From:
Sent: 01 December 2025 20:57
To: Farzana Tabasum
Subject: Formal objection to unsafe retaining wall 2025/45/90964/E

Formal Objection – Retaining Wall Submission (Condition 16)

2025/45/90964/E

Land off Westgate Cleckheaton bd19

Drawing No: SK24-5558-F-1-03 Revision: 0

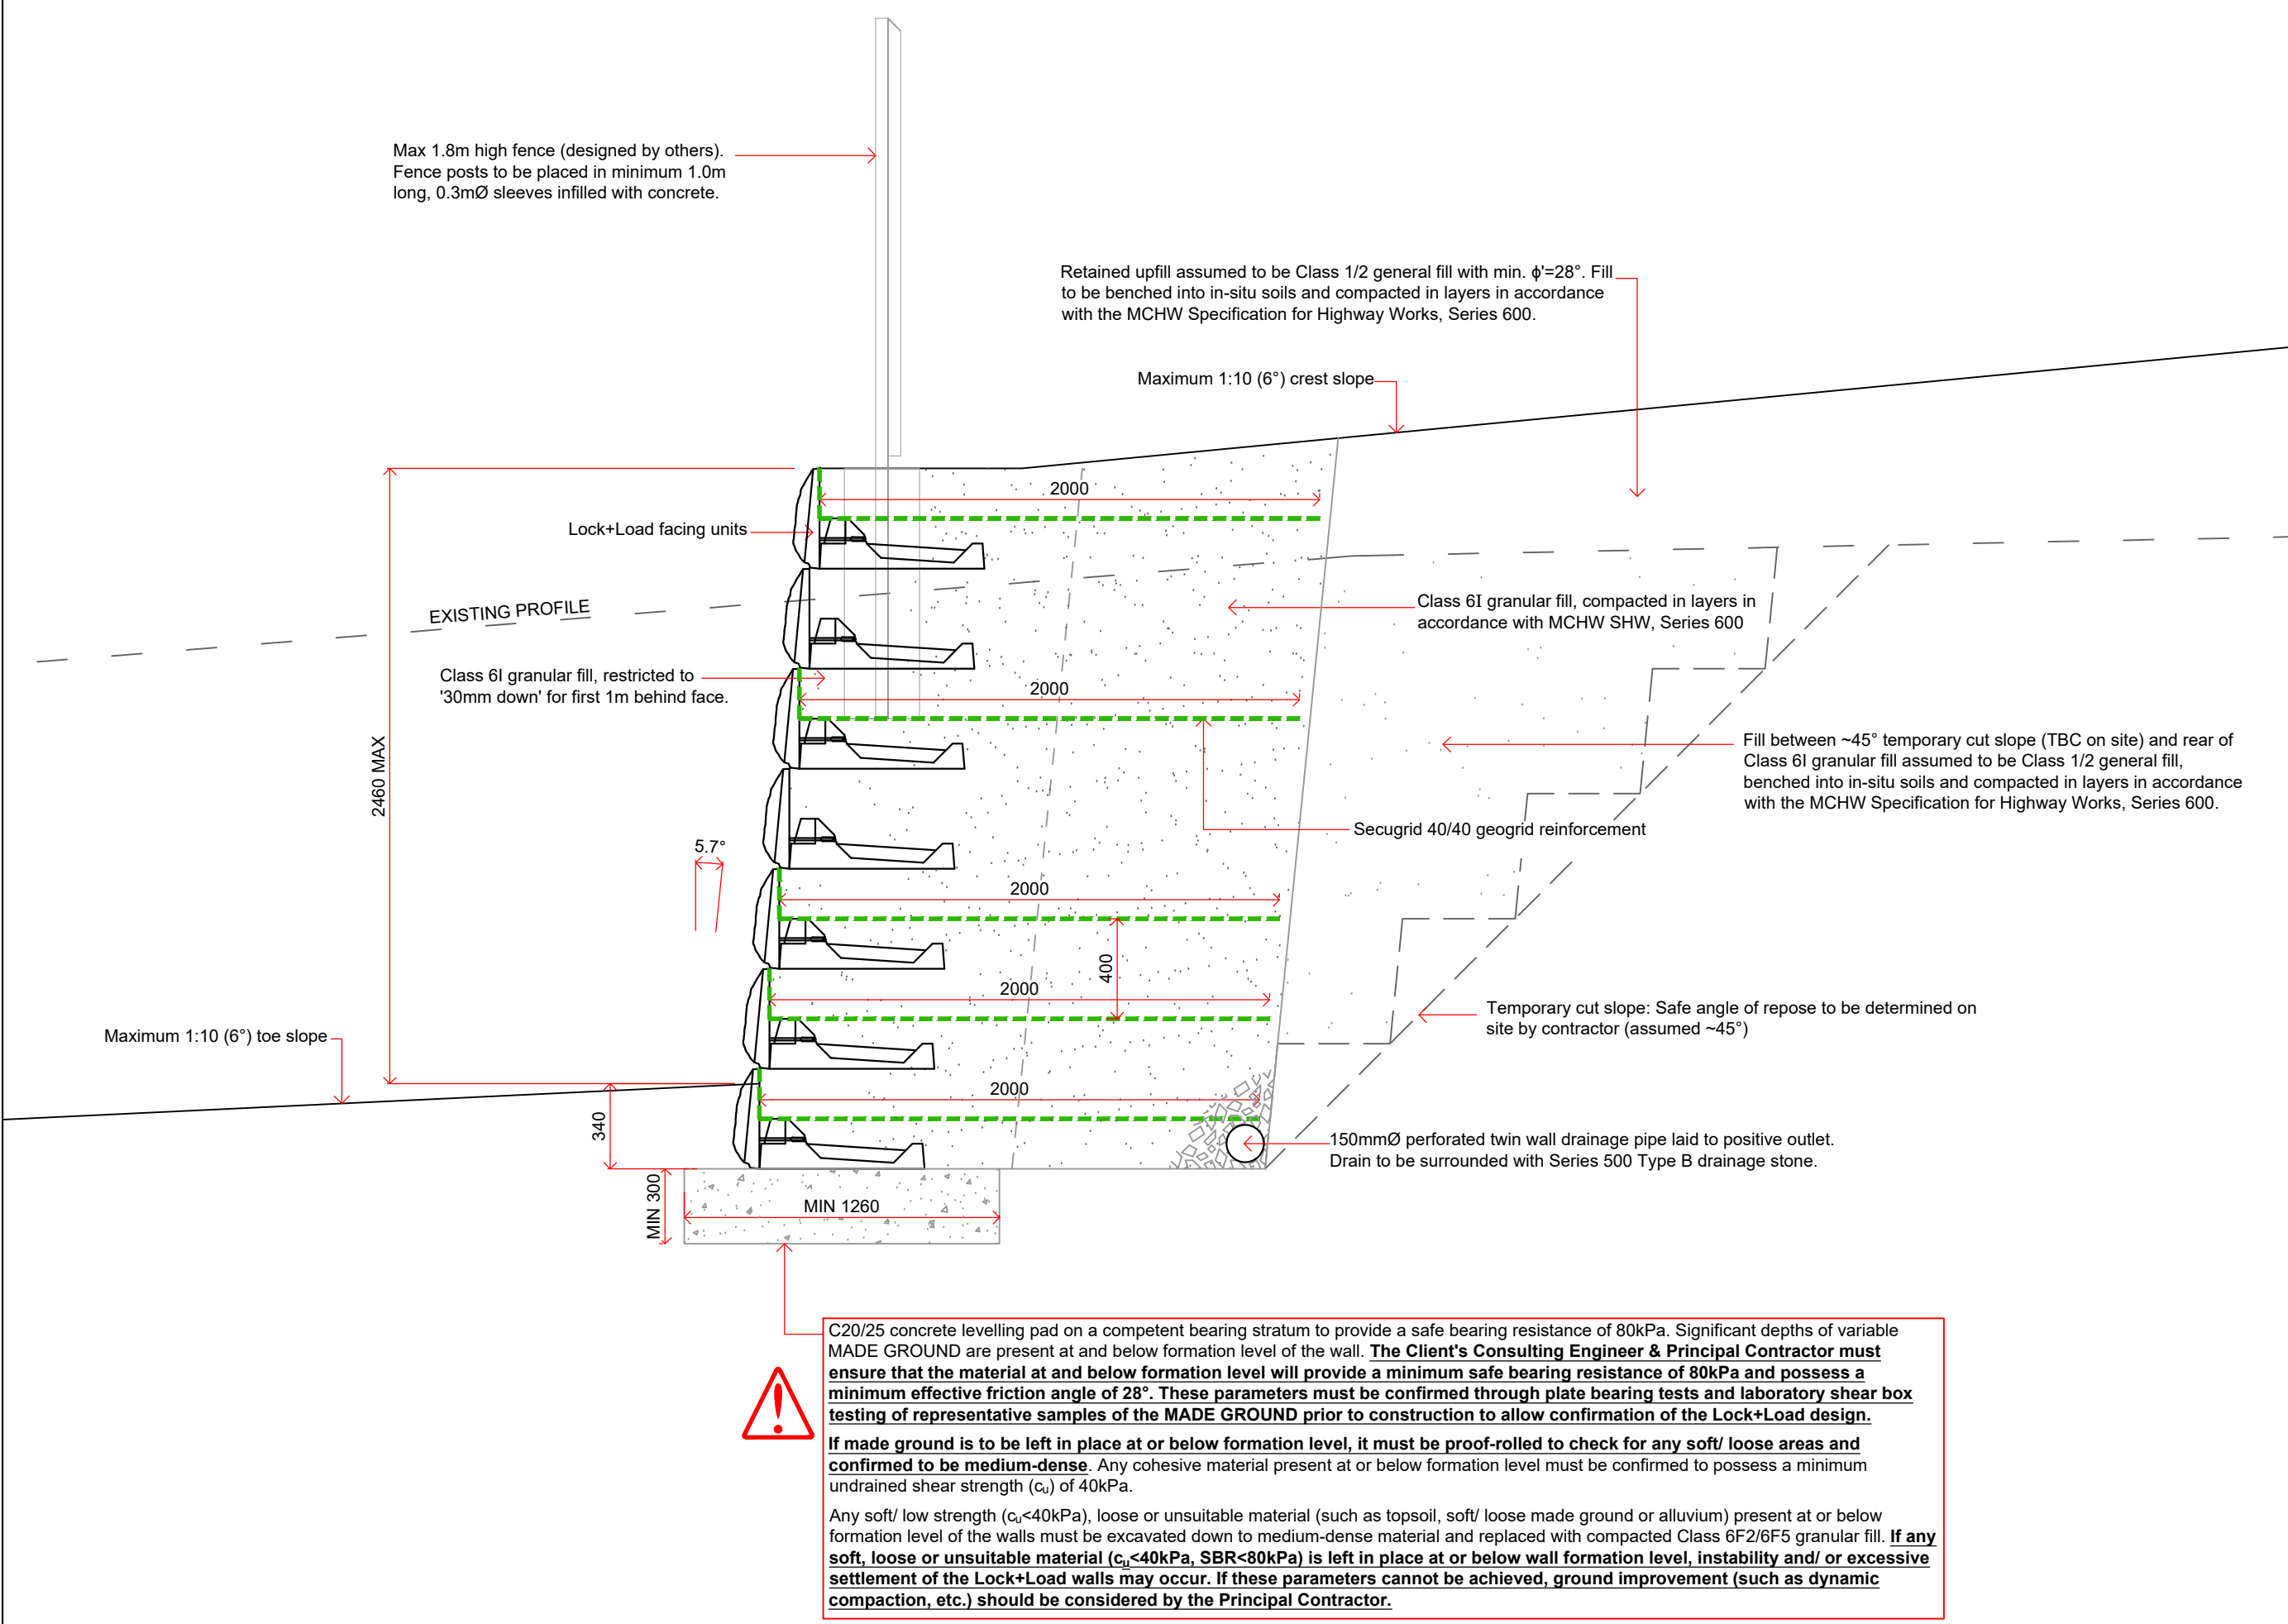
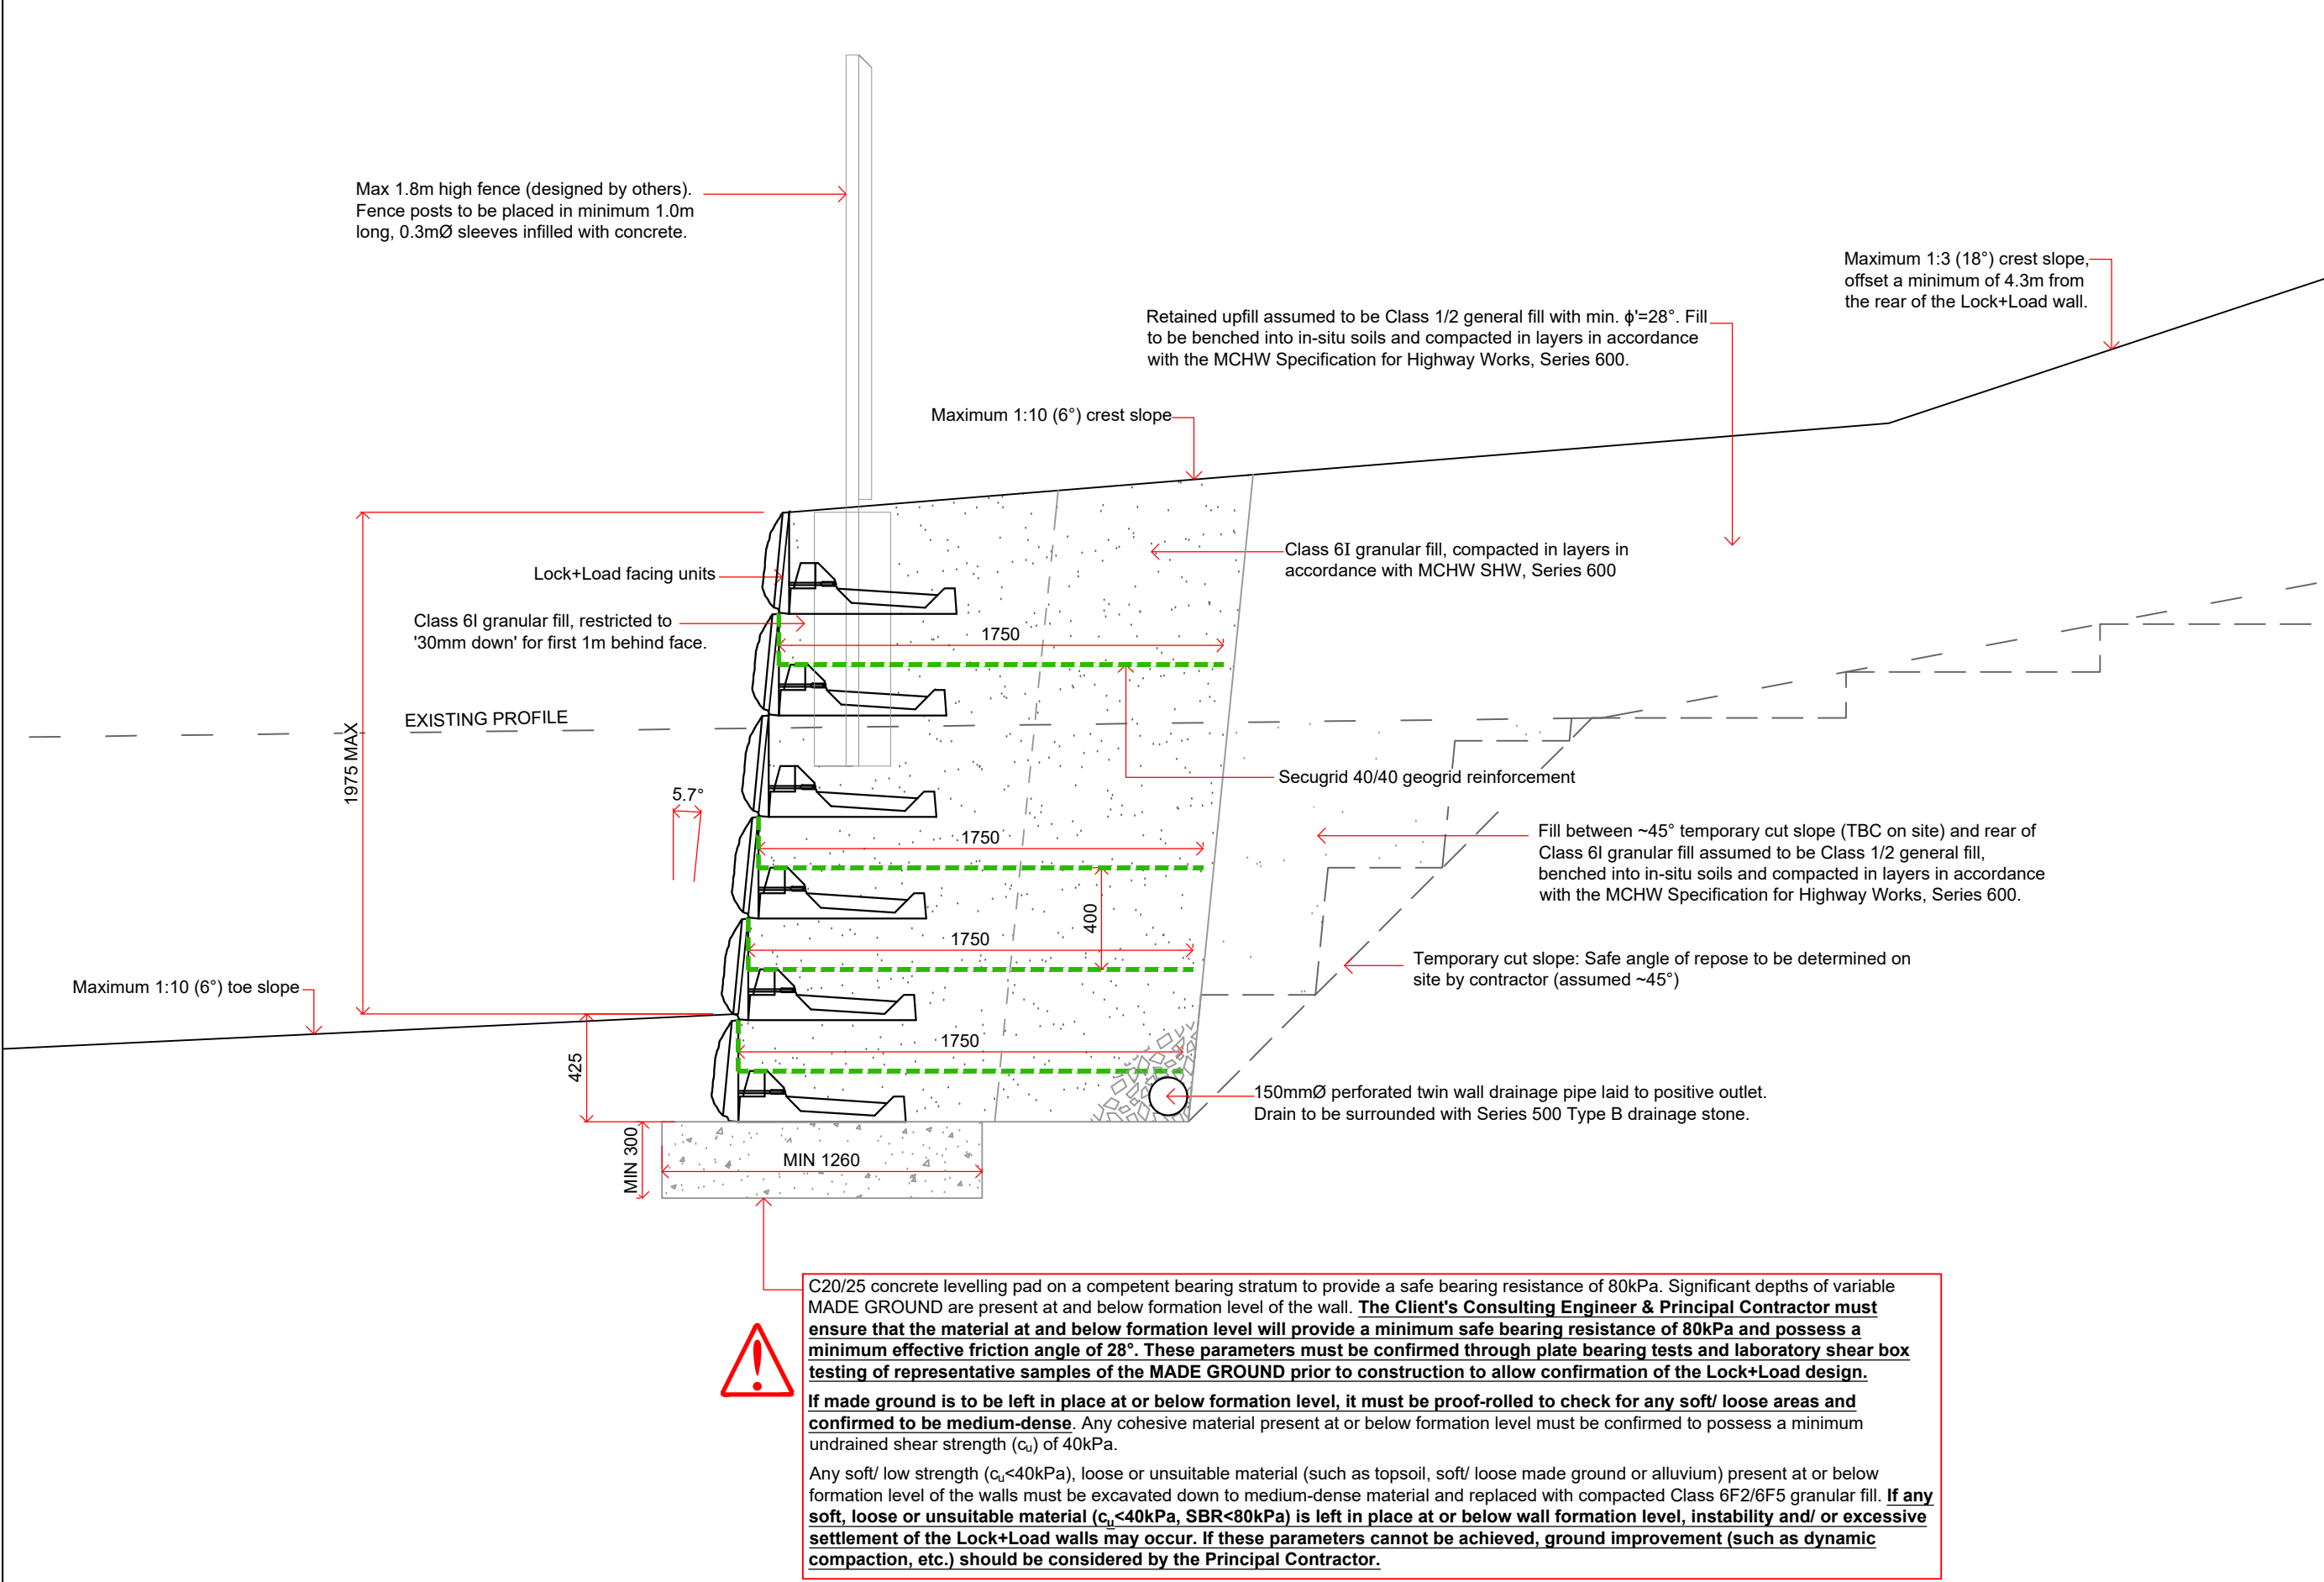
The drawings even contain a note requiring these checks to be carried out, yet they have not been completed. This omission is extremely serious given that the ground at this boundary is weak, variable and partially unstable, with collapsing trial pits, rapid groundwater ingress and inconsistent made ground containing ash, clinker, slag, brick dust and industrial waste.
